Response to Submissions

Wallerawang Quarry (DA 344-11-2001)

July 2017

Figure 4.5
FINAL LANDFORM.

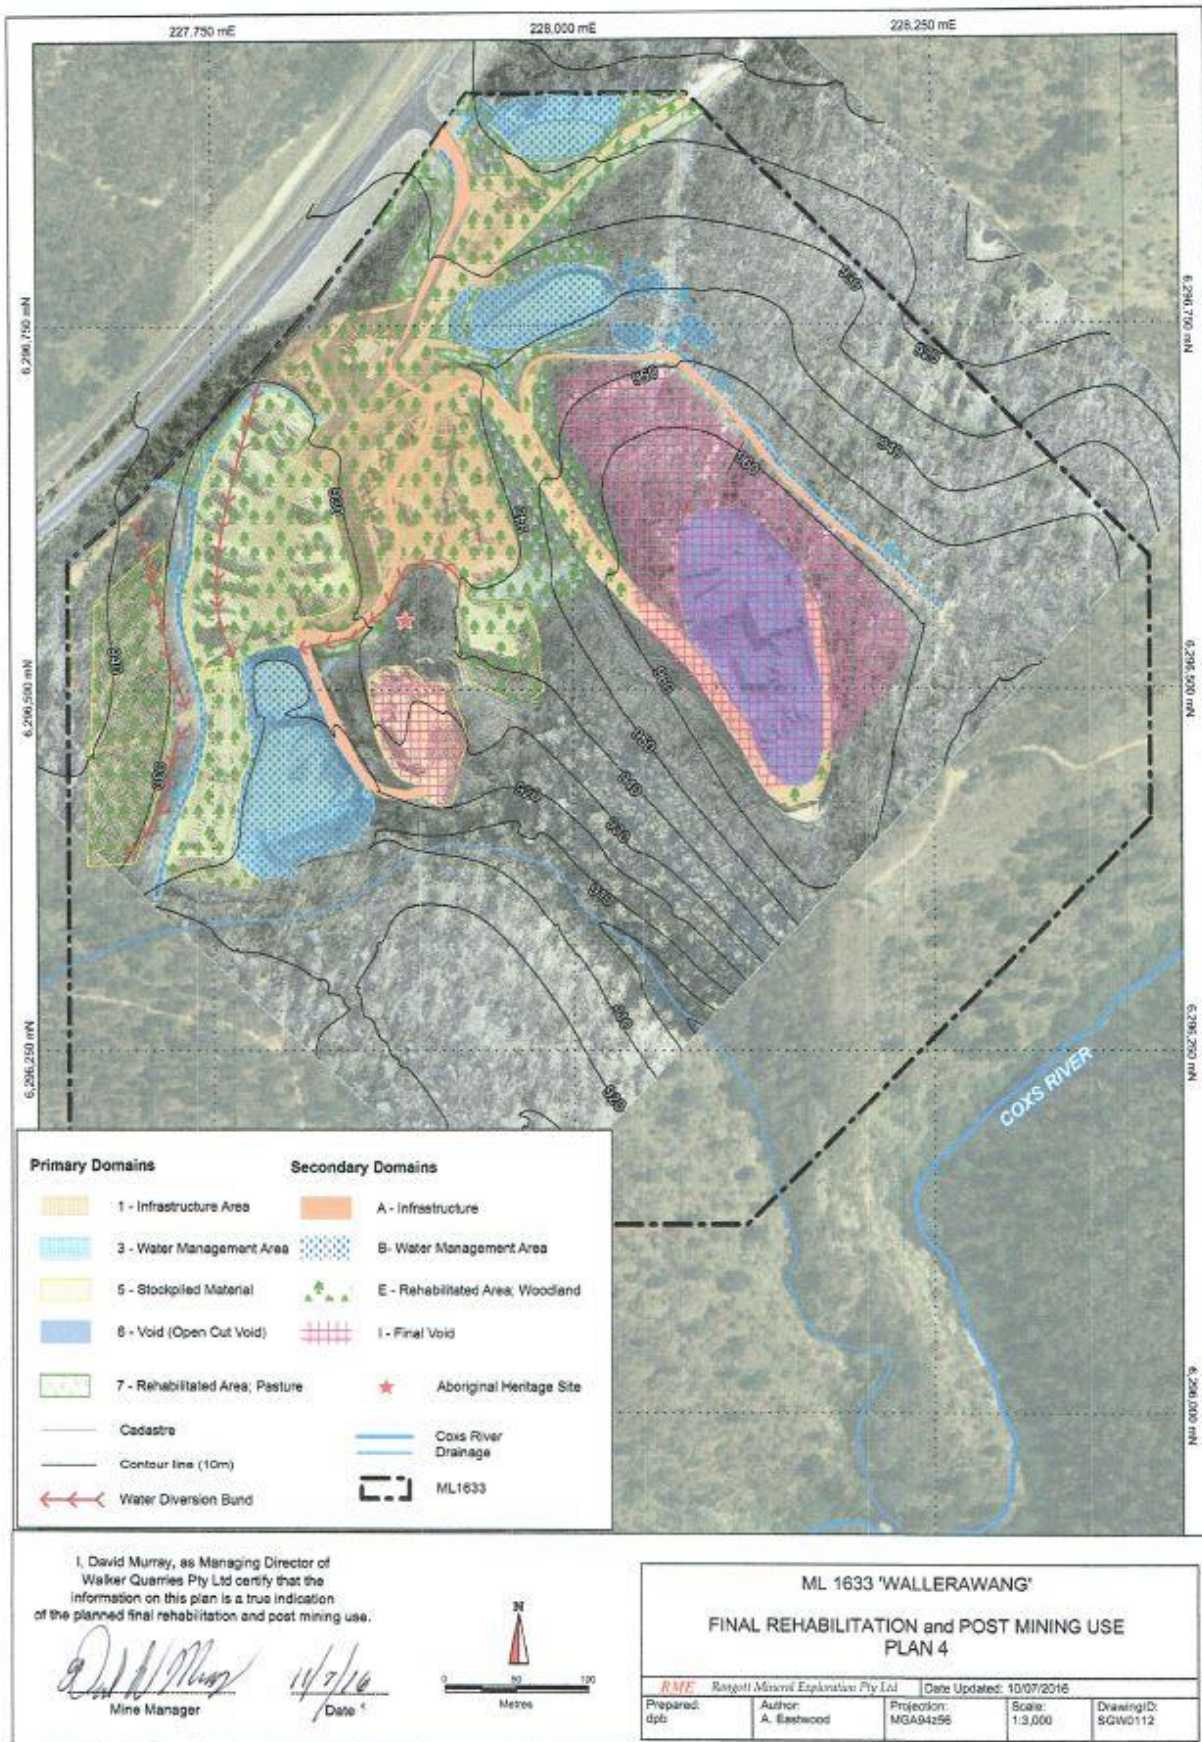
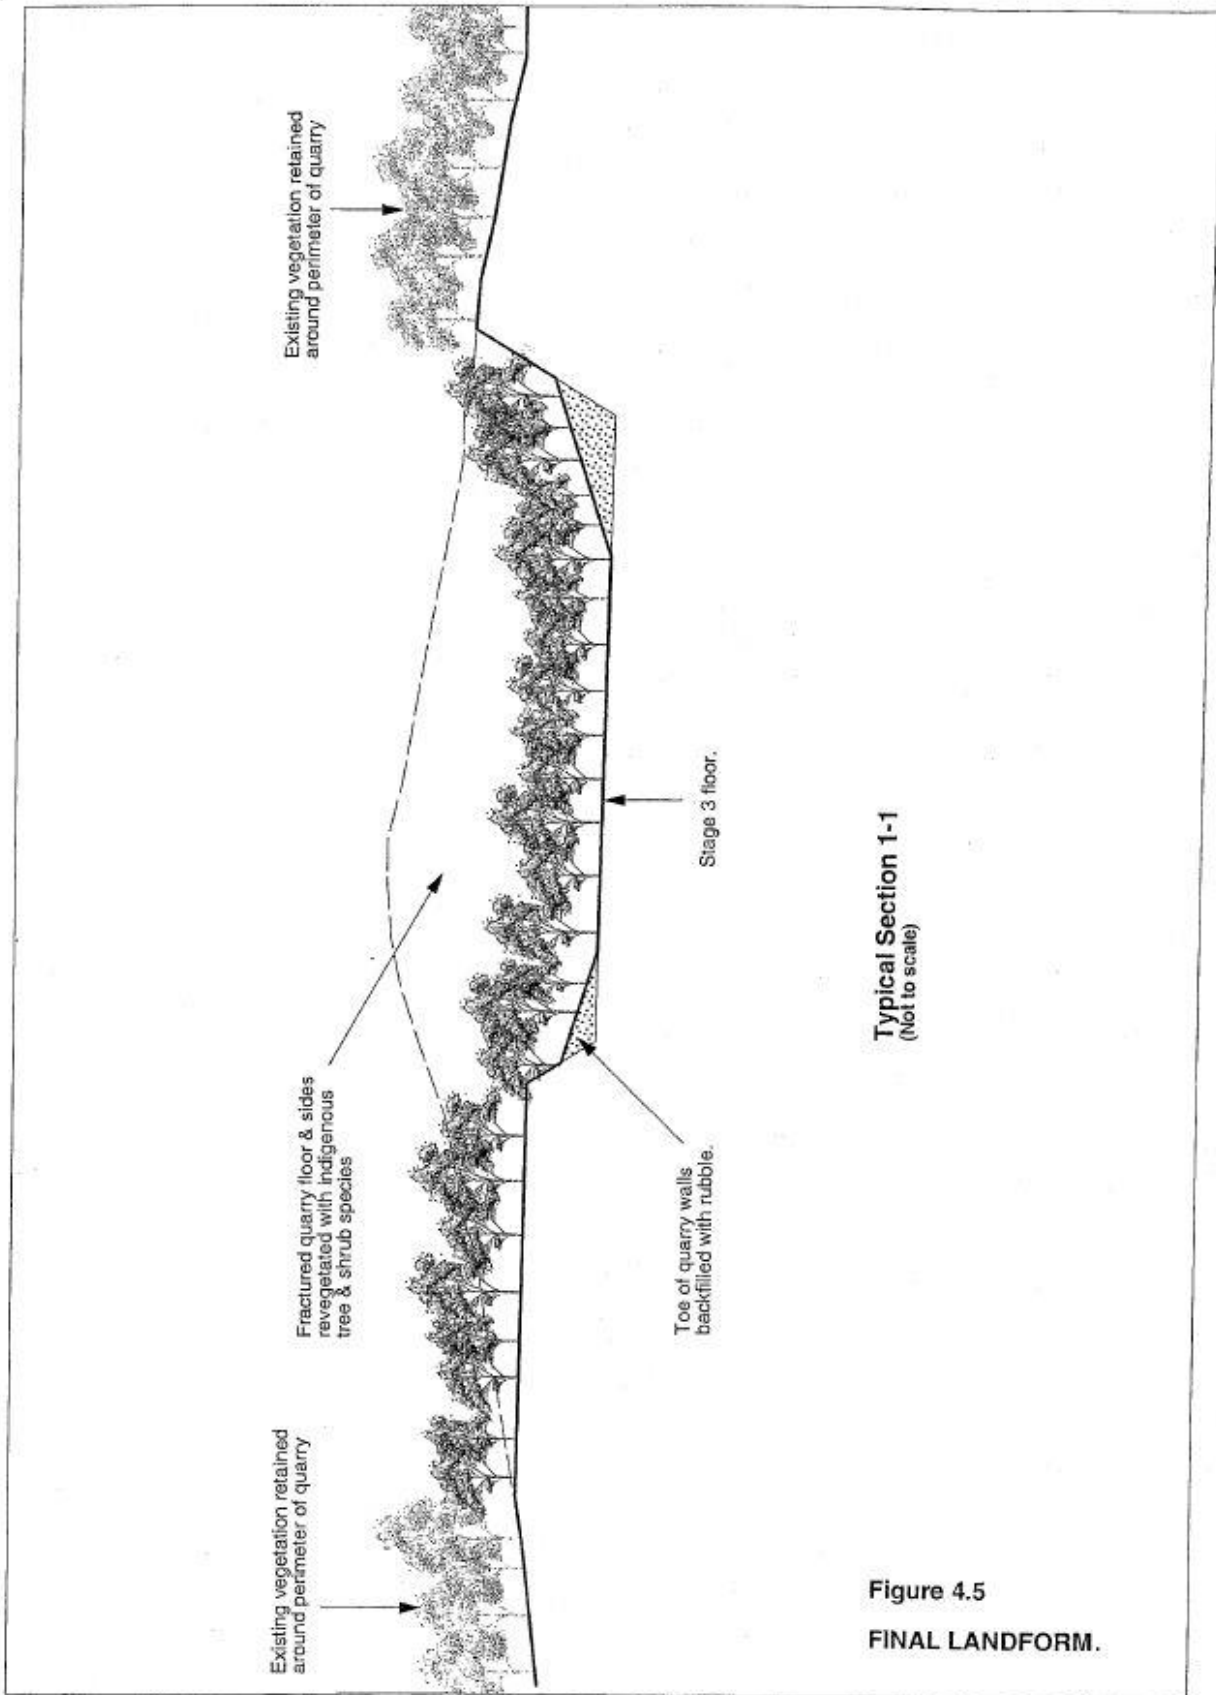
It is noted that within Appendix 1 of the EA is an "Approved Final Landform" from the MOP. It should be noted that the MOP must be consistent with the Development Consent, and therefore the MOP approved final landform should in no way influence the final landform approved in the Development Consent.

A response to these statements is included in Section 2.1. In summary, however, we remain of the belief that the fact that the proposed rehabilitation objectives, methods, criteria and measurement have been previously reviewed and approved to be highly relevant and not

inappropriate to the current assessment. We reiterate the point that the DRG, who are principal regulator of rehabilitation on mining leases, has previously considered the proposed final landform, rehabilitation objectives, methods, management and measurement to be satisfactory.

Figure 7
MODIFIED FINAL LANDFORM

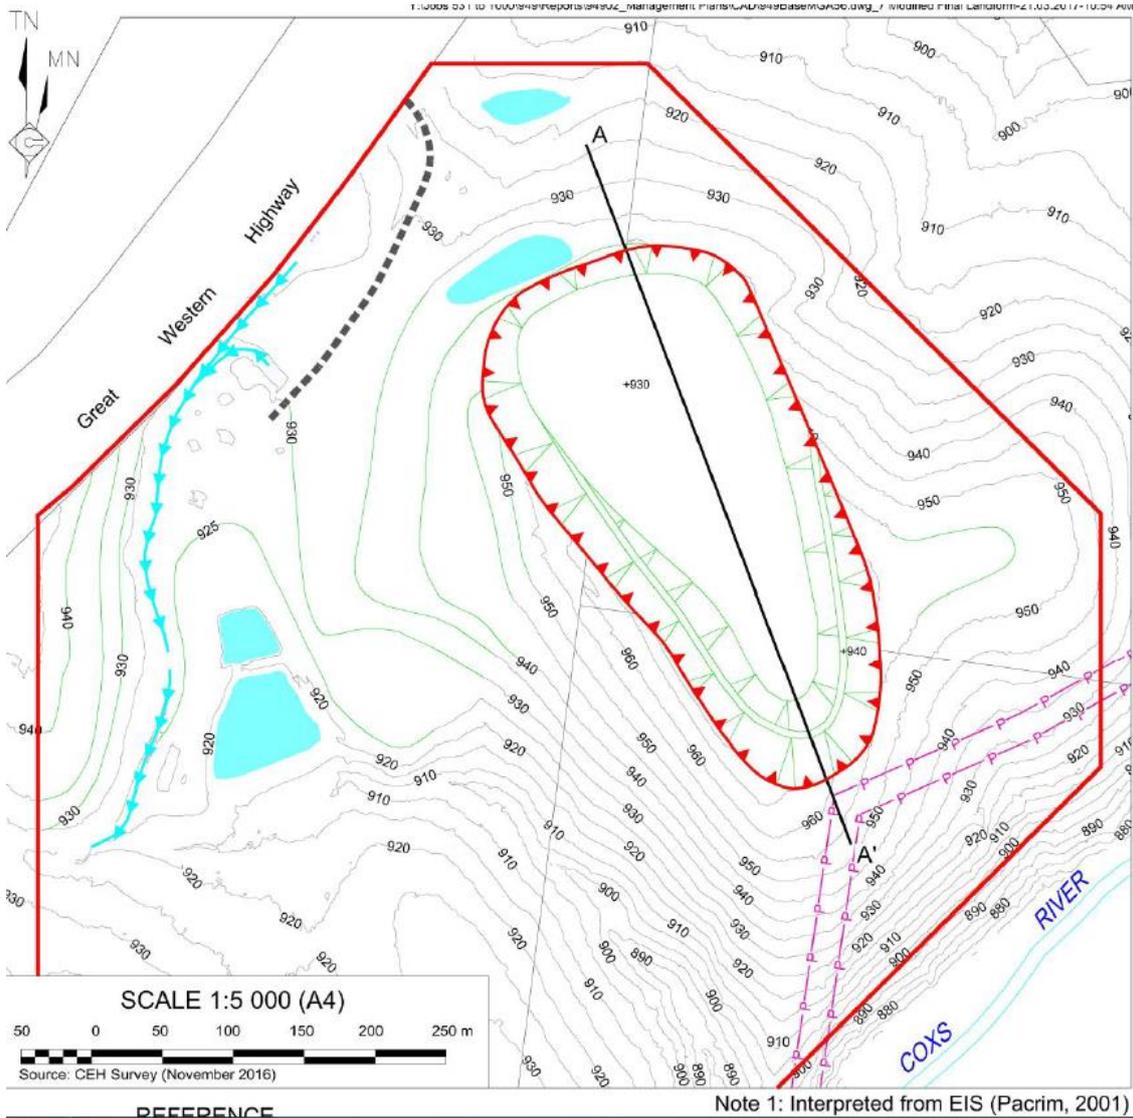
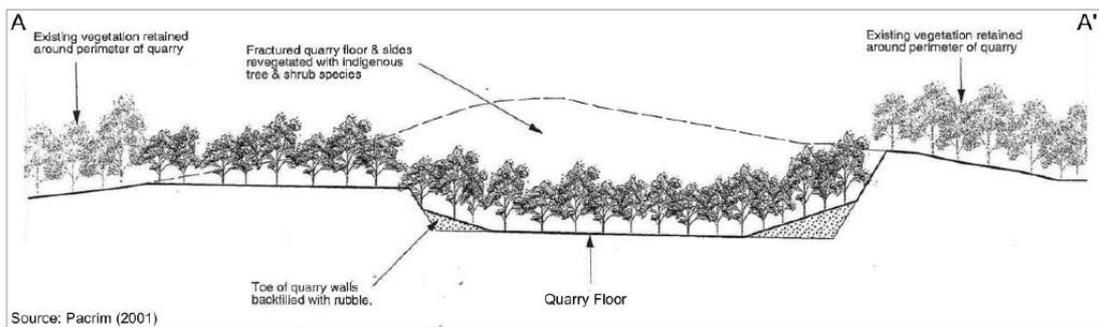
A review of aspects of the site or operations which may present barriers, limitations or risks to effective rehabilitation needs to be included. Also additional detail about the rehabilitation strategy to meet the target vegetation community(s) should be included, including methods of seeding/planting and species mix. Justification should be provided for the use of slopes up to 25 degrees (Table 14 of the EA) – Indicative SEARs (mining) (2015) (l)(o)(p).

Slopes of up to 25° have been proposed for sections of the WSEA to:

- a) reduce the overall disturbance required to create the final landform; and
- b) replicate slopes in the immediate vicinity of the Quarry.

By limiting the earthworks required to create the landform, the risk of detrimental impacts on the growth medium are minimised. By replicating natural landforms, the likelihood of replicating the vegetation communities of the local setting would be increased. In particular, Native Blackthorn, which is habitat for the threatened Purple copper butterfly, prefers sloping landforms with northerly aspect. The proposed landform of the WSEA attempts to replicate these conditions.

The above notwithstanding, should DRG require the landform be reduced to a slope of 18°, the Applicant would comply.
